From: Nia Russell [REDACTED]
Sent: 12 October 2017 11:11
To: Michael Eastham
Subject: Re: Saltbox application (BE/102/17/OUT) and Highway / Transport comments

From: Michael Eastham
Sent: 09 October 2017 13:59
To: 'Nia Russell'
Subject: RE: FRA v4 for BE/102/17/OUT

From: Amol Pisal [REDACTED] **Sent:** 04 October 2017 17:07
To: Ian Gledhill **Cc:** Tony Chapman **Subject:** Bognor Regis - Drawings

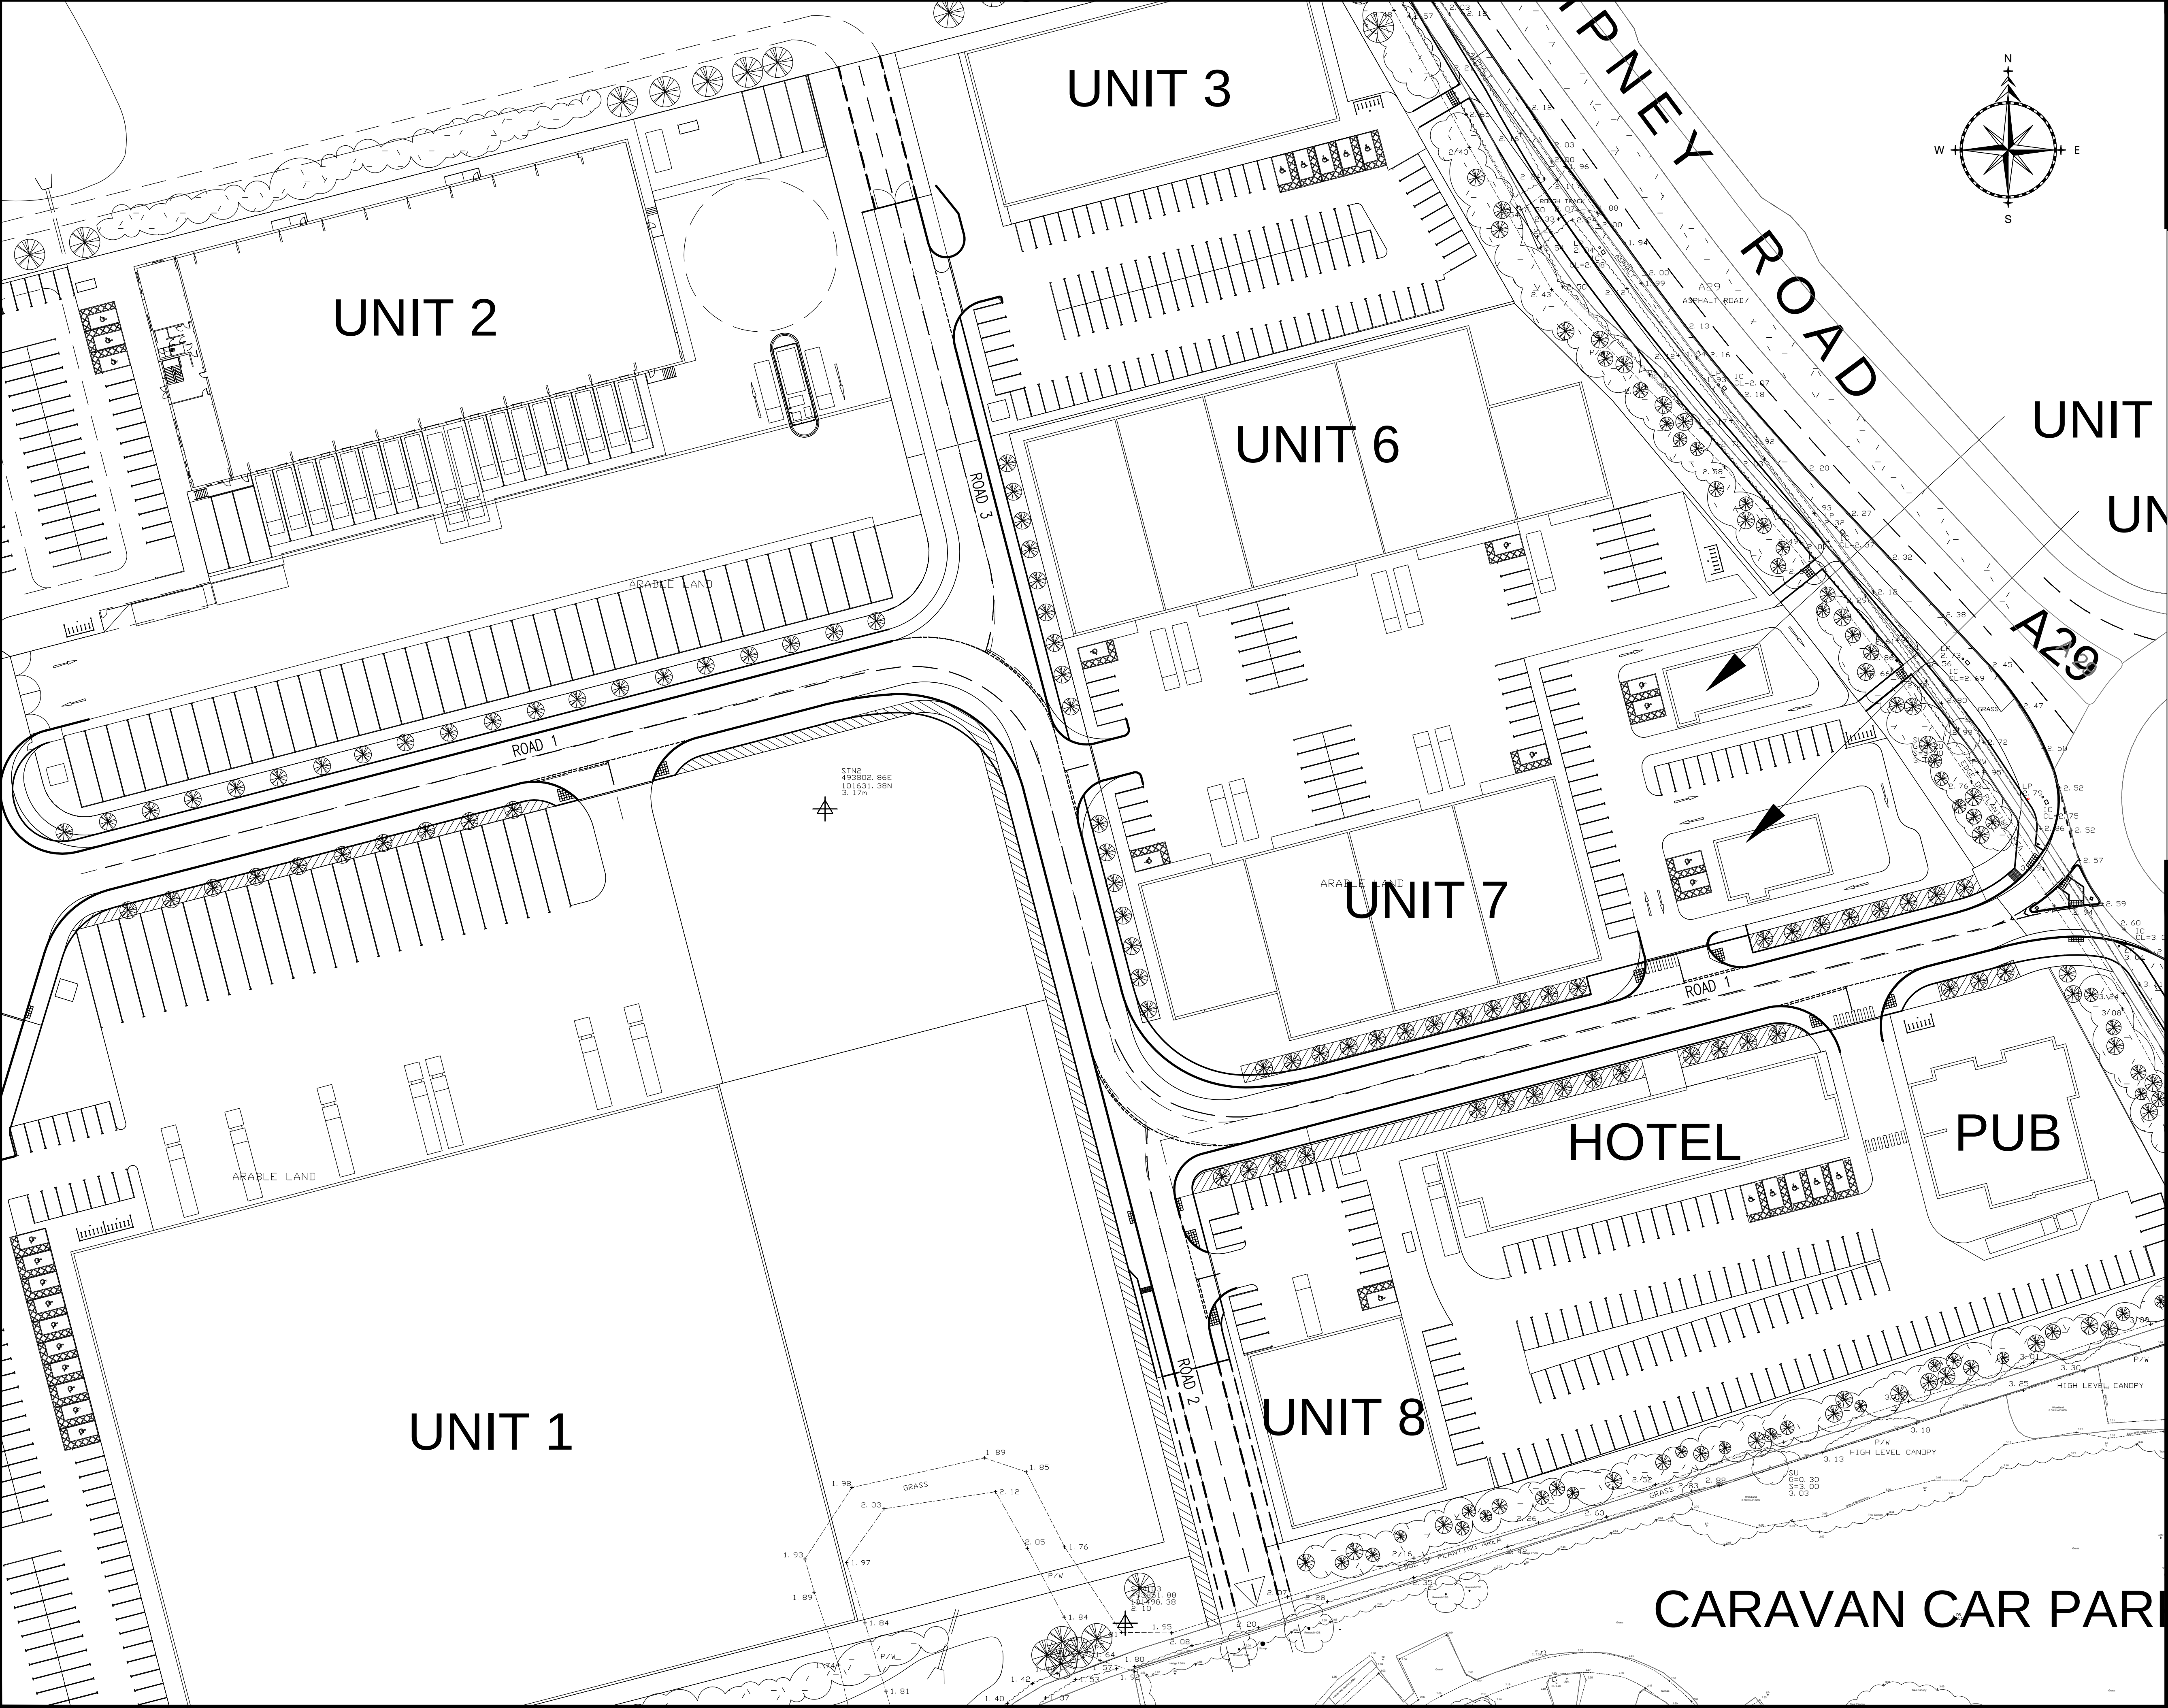
For the cycle route, it's evident that a 3metre width can be achieved without any apparent issue. My concern however is that the route has no onward connectivity. Cyclists would simply be expected to re-join the northbound carriageway to continue their journey. There is also no connection to enable cyclists on the southern bound A29 to reach the proposed cycle way; it would effectively be usable only by those northbound cyclists. Based on this I'd therefore question whether there is any benefit to the provision of the route as shown. My view is that it would be far more beneficial to contribute further towards other sustainable transport improvements rather than providing this link.

For those works proposed as part of the development, I would ask for a plan showing the extent of the works at this stage to demonstrate that these are deliverable and meet current standards. I would prefer this to be the subject of a Stage 1 RSA as part of the planning application. However providing it is demonstrated that a to standard route can be provided, then I would be satisfied to recommend a Grampian style condition instead that ensures a combined Stage 1 and 2 RSA is secured ahead of development commencing.

I attach our revised drawing H1194-101-B showing the extent of the off-site highway works which would be undertaken under a S278 Agreement.

As far as I am aware the only outstanding matter is the contribution towards a foot/cycleway along Shripney Road. The alternative would be to construct a 3.0m wide footway which would link with the village of Shripney to the north and provide pedestrian access to the Salt Box site. The footway could then be converted to a cycleway in the future by WSCC.
